KITTITAS COUNTY

MEMORANDUM

TO: All Staff
FROM: Public Works Plan Review Team
DATE: January 21, 2025
SUBJECT: SP-25-00002 Sageview

SAGEVIEW BLA/SHORT PLAT
PART OF SECTION 29, T. 17 N., R. 20 E., W.M.
KITTITAS COUNTY, WASHINGTON

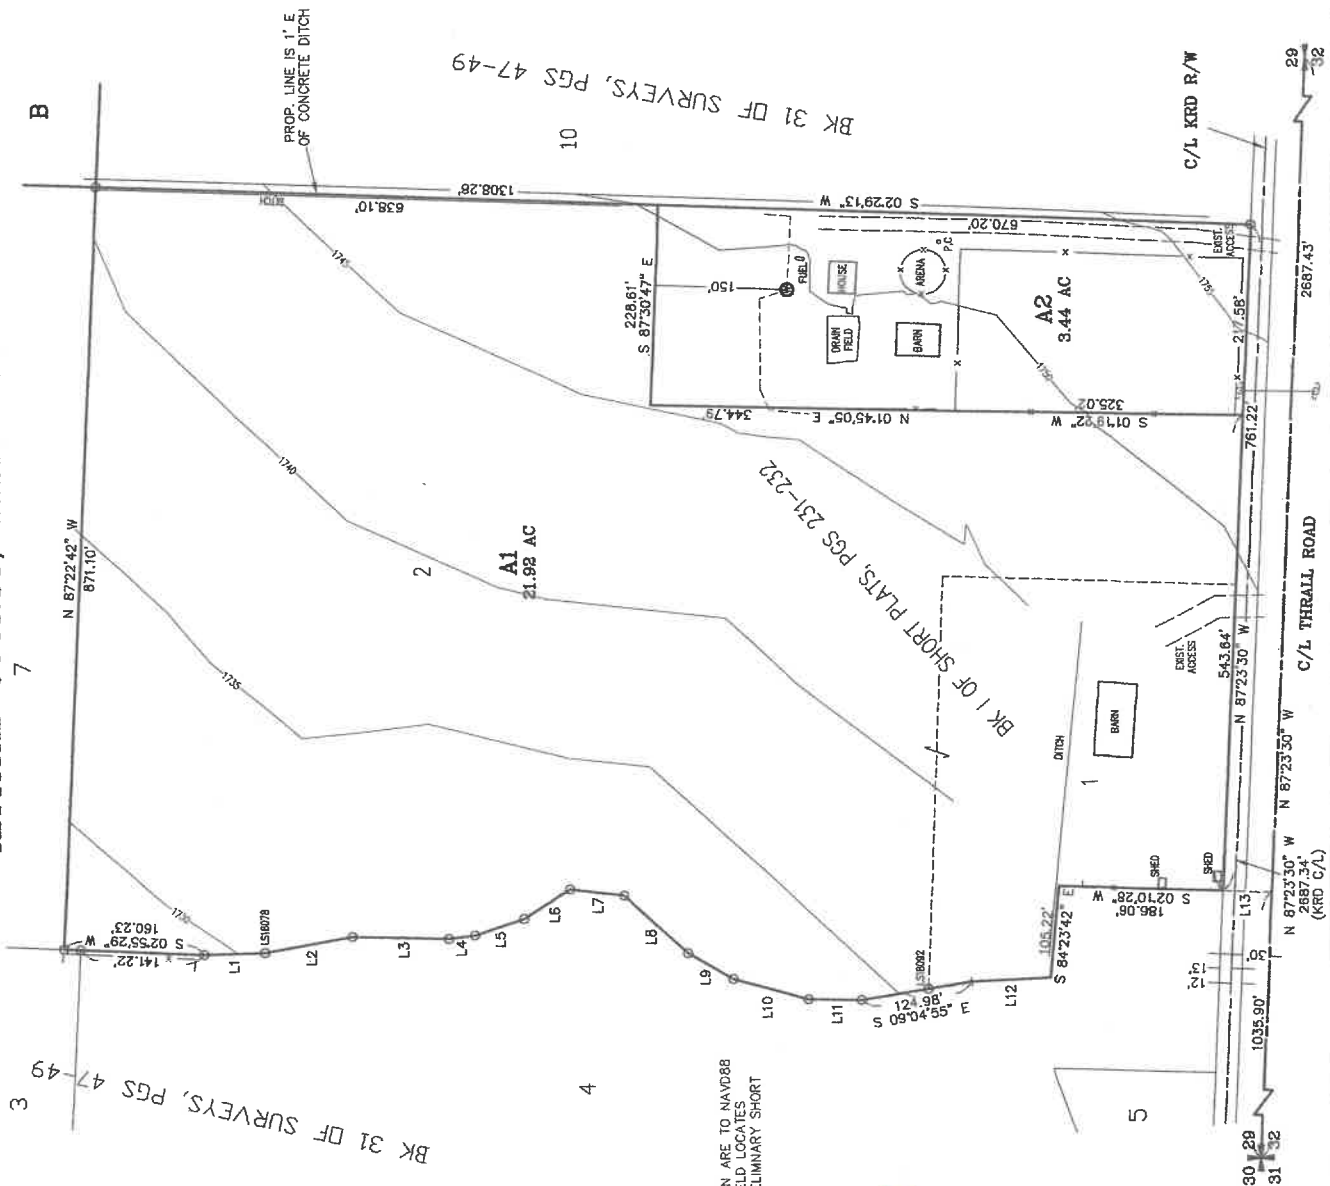
<p>property will be viewed as being subject to short plat standards, and will be treated as such.</p> <ol style="list-style-type: none"> 4. Sheet 1 – Please clearly show a note similar to the following: “This sheet represents adjustment to boundary lines prior to Short Plat recorded simultaneously and shown on subsequent pages”. 5. Sheet 1 – Please show the following note (or something similar) on Lot A: “Lot A is a transitional parcel to be further subdivided on subsequent pages and should not be referenced as a legal lot after recording”. 6. Sheet 1 – Please identify previous and proposed boundaries. 7. Please set and show corners per Short Plat standards. 8. Sheet 2 – Elevation Datum note contains minor typo. 9. Please include a survey narrative explaining the BLA and simultaneous Short Platting. 10. Final document shall be filed as a short plat. All lots shall be referenced as being a portion of a short plat.
